CITY OF ALBUQUERQUE

July 16, 2013

Re: La Luz del Oeste, Unit 4 Grading and Drainage Plan
Engineer's Stamp dated 06-06-2013 (F-11/D002A)

**GRADING AND DRAINAGE  
PLAN**

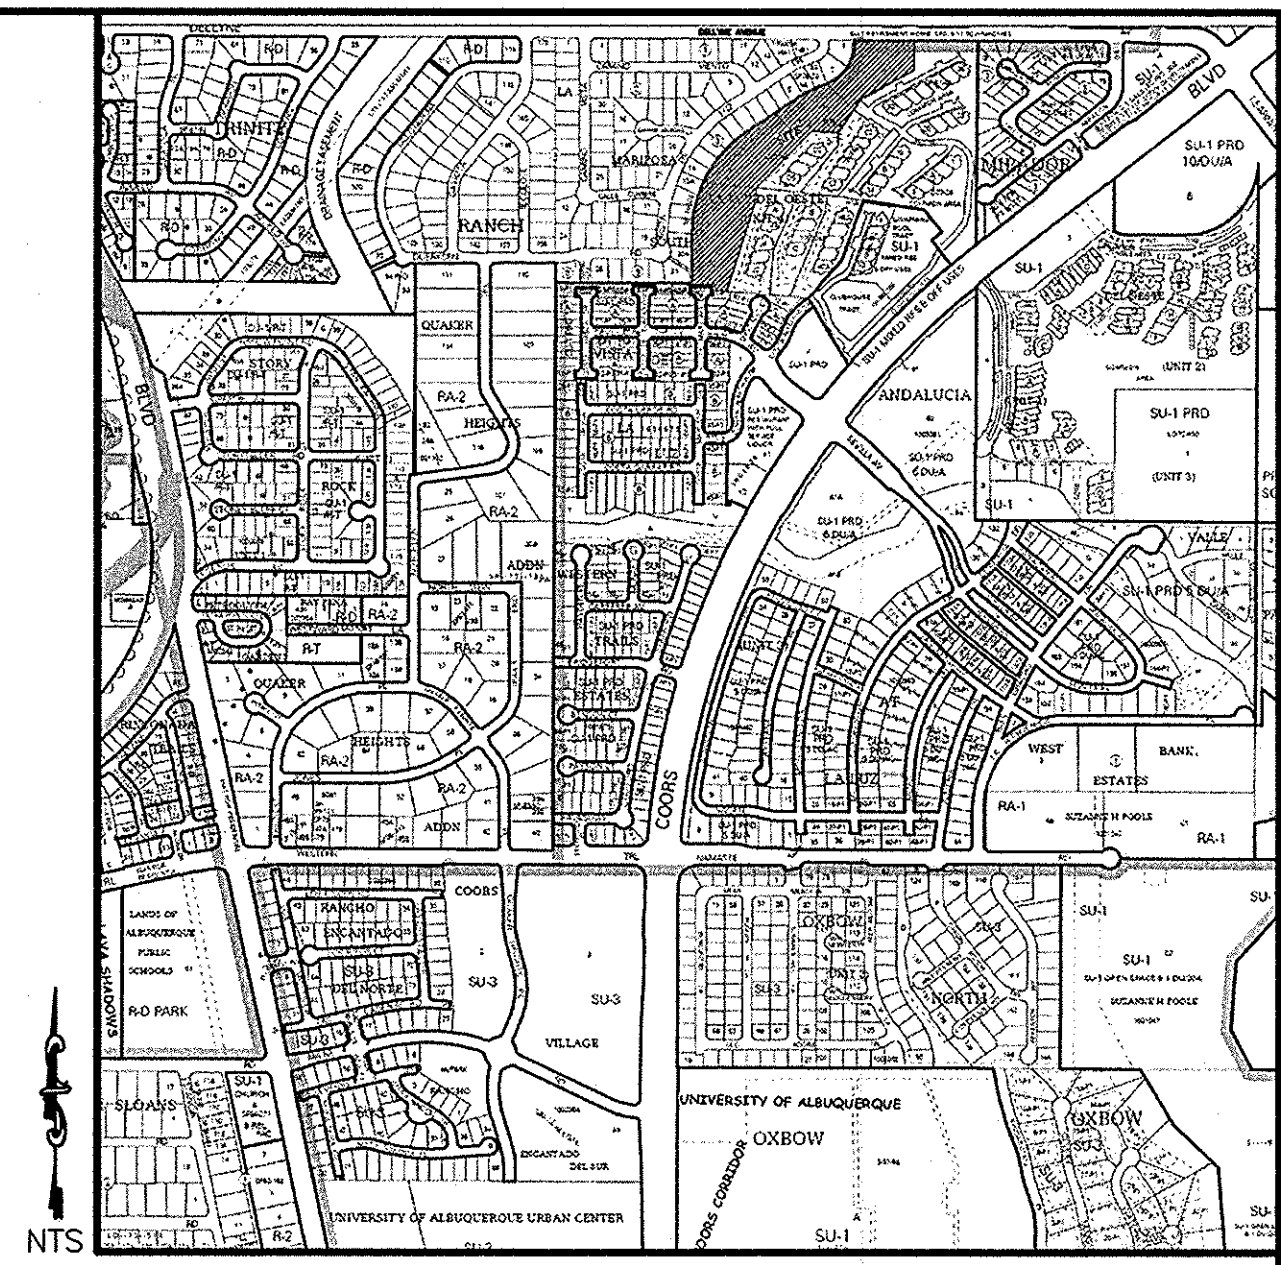
- Please provide a copy of this plat as well as the plats for the adjacent units to ensure proper access and that drainage easements are in place.
- Provide a narrative describing where Basin 105 and Basin 110 drain to.
- It is not clear how developed flows reach the proposed pond in Basin 111 on its eastern edge. Similar issues with the pond that lies in Basin 113.
- Label all existing contours.
- How will erosion control measures around the retention ponds be accomplished?
- Additional spot elevations are needed around all boundary lines.
- Label all streets, both public and private on the grading and drainage plan.
- Be advised that an Erosion and Sediment Control Plan will need to be prepared and approved by Hydrology prior to issuance of Building Permit Approval.
